Consultation Response from KC Highways Development Management		
2026/90620 Central Warehouse, Bradford Road, Batley, WF17 5LW		
Demolition of existing building and erection of food/drink building with drive thru lane (Class E)		
Date Responded: 07/05/26	Responding Officer: M Zenner	Responding Ref: 13-10SE/9

RECOMMENDATION: HDM considers there is insufficient information to assess the potential highway impacts of the proposals fully. There are concerns that the layout appears cramped and the intensification of uses on the site could cause safety conflicts both within the site and at the access points onto Bradford Road.

Plan Number: 251072 - 201

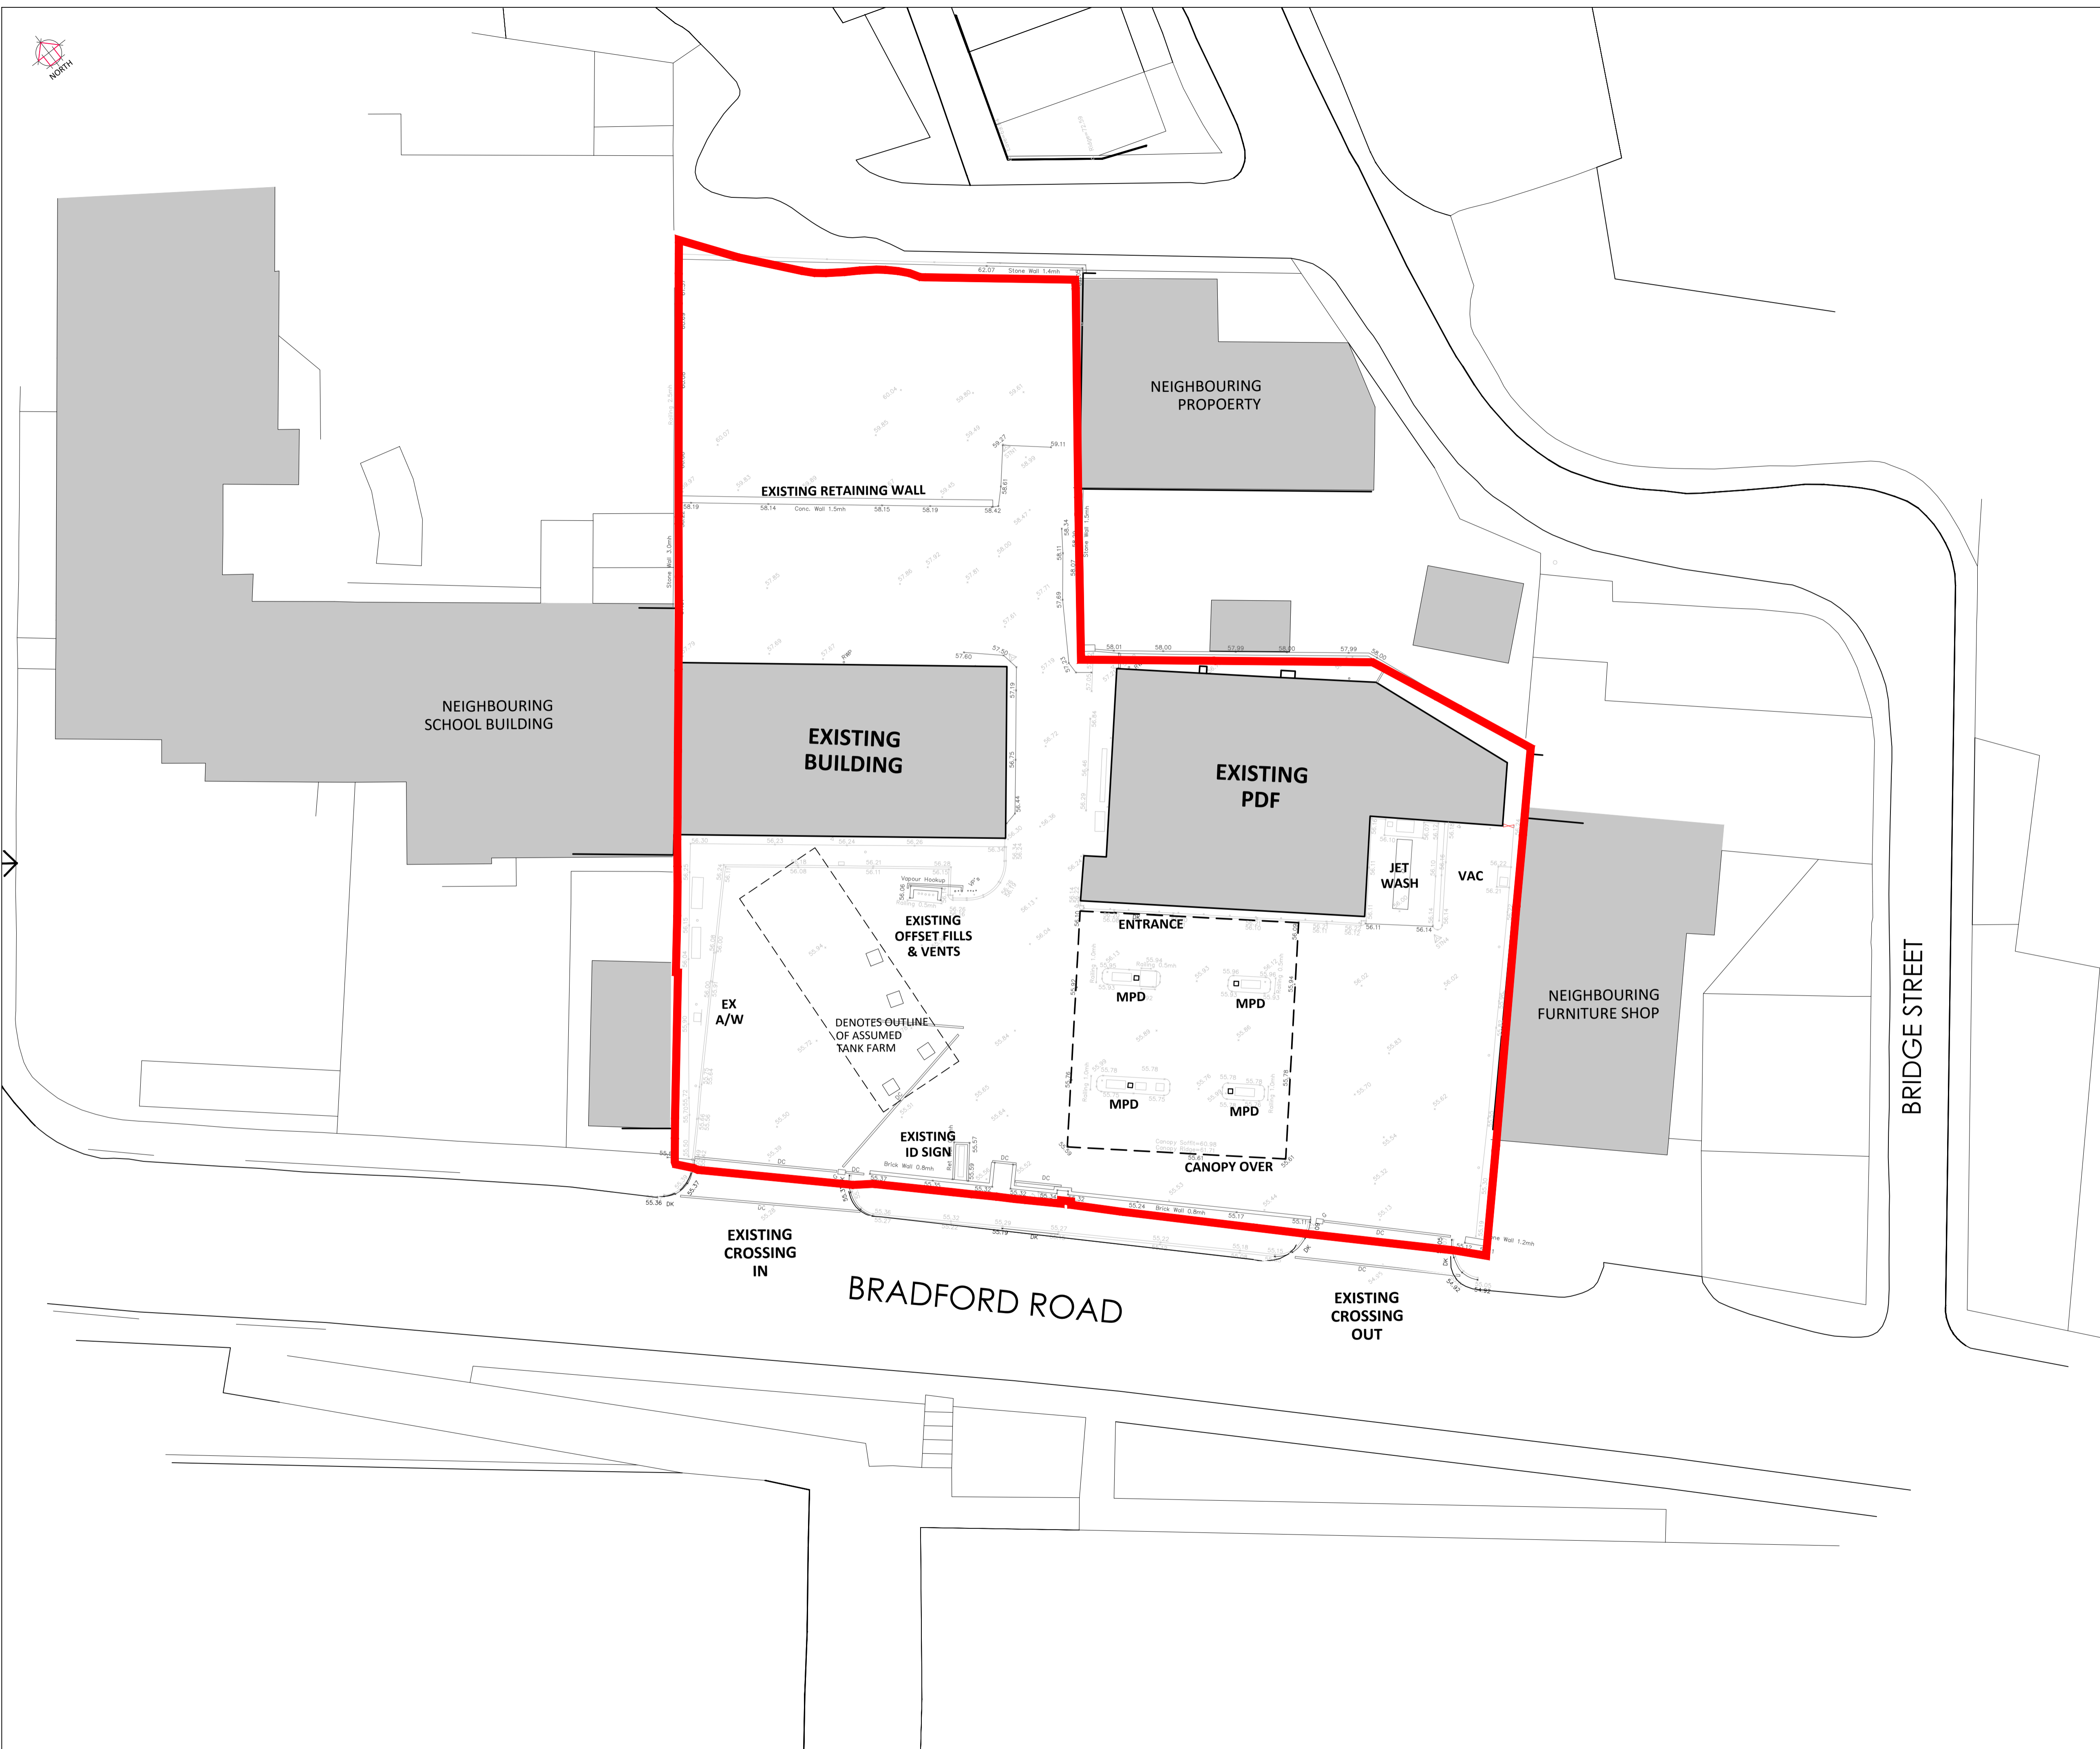
It is HDM's understanding that the existing site currently hosts a Petrol Filling Station and associated retail unit with additional facilities such as a jet wash and a vacuuming bay adjacent to the building to the south and there is an air/water point located to the north along the site boundary adjacent to two parcel lockers.

There is also an existing building located to the north of the retail building which is stated to be in commercial use, the building is currently in use by B & D Bolts and has car parking to the front and rear of the site. There is a gated access to a neighbouring site that connects to the rear car park and a grassed area behind a retaining wall at the rear of the car park.

There are currently two vehicular access points at the site accessed from Bradford Road, the existing site layout plan indicates that these are an 'in' (northern access) and an 'out' (southern access) although HDM is of the view that vehicles exiting the B & D Bolts site are more likely to exit from the northern access closest to their building rather than pass through the pumps at the Petrol Filling Station.

There are currently two vehicular access points at the site accessed from Bradford Road, the existing site layout plan indicates that these are an 'in' (northern access) and an 'out' (southern access) although HDM is of the view that vehicles exiting the B & D Bolts site are more likely to exit from the northern access closest to their building rather than pass through the pumps at the Petrol Filling Station and furthermore there are right turn markings located on Bradford Road adjacent to both site access points.

**CYCLE HOOP DETAIL**

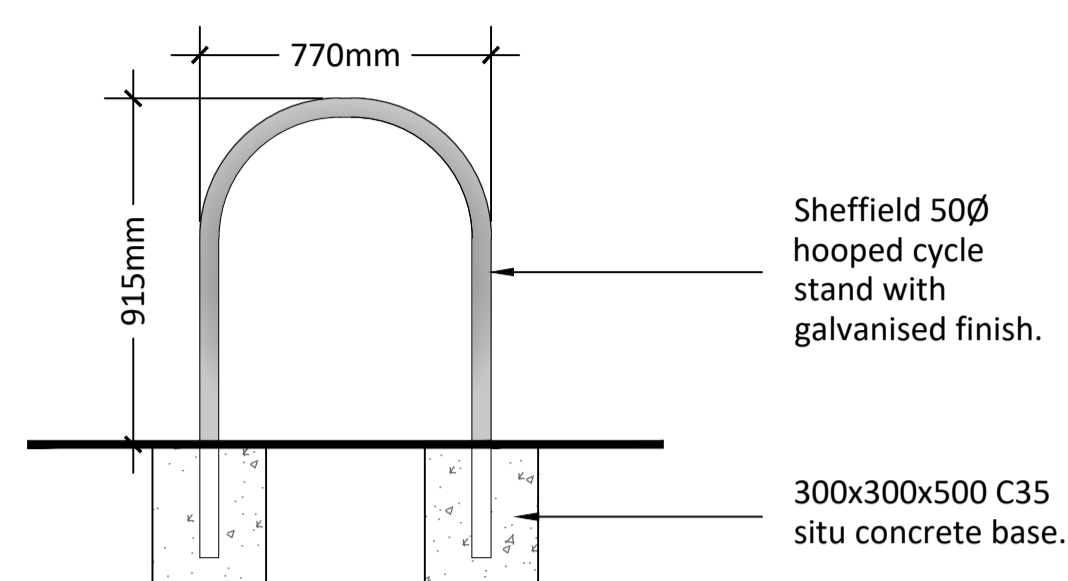
Kirklees Council's Highway Design Guide does not have specific cycle parking standards for retail and food / drink uses, however, The Department For Transport Local Transport Note 1/20 provides notional standards on Page 134 of the document, setting out both long stay and short stay standards and also provides guidance on the design of facilities. All cycle parking should be located at ground floor level, long stay for staff should be provided in a secure covered arrangement and short stay visitor facilities should be located in a well overlooked location with natural surveillance close to the proposed destinations. The cycle parking proposed is remote from the proposed building and therefore is not considered fit for purpose and should be reviewed.

**BOLLARD DETAIL**

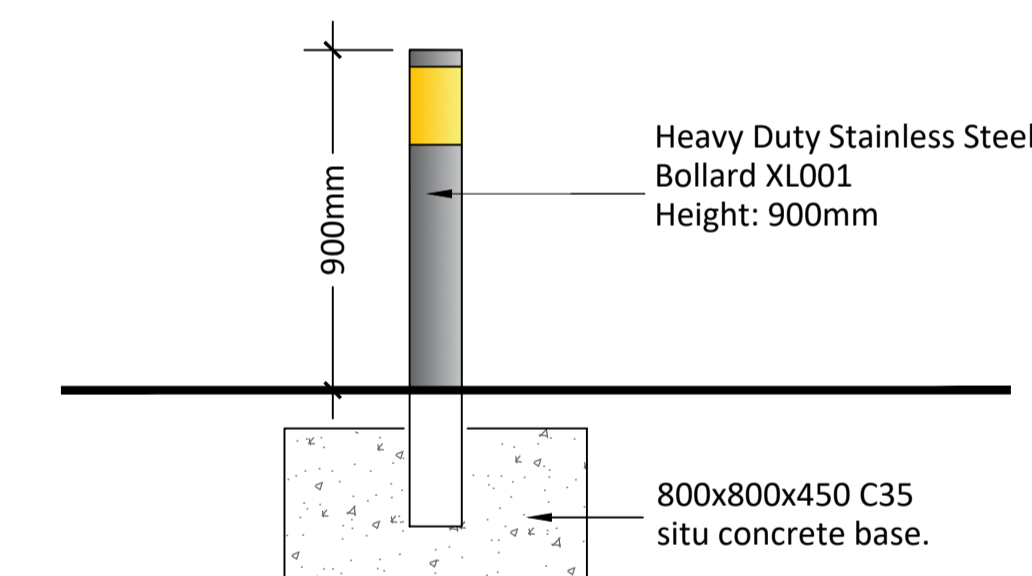
The proposed drive thru is shown with sliding doors to the frontage but the site layout plan shows a narrow strip of hard standing at the front of the building with bollards located along the full extent of it, which would mean pedestrian access is not possible.
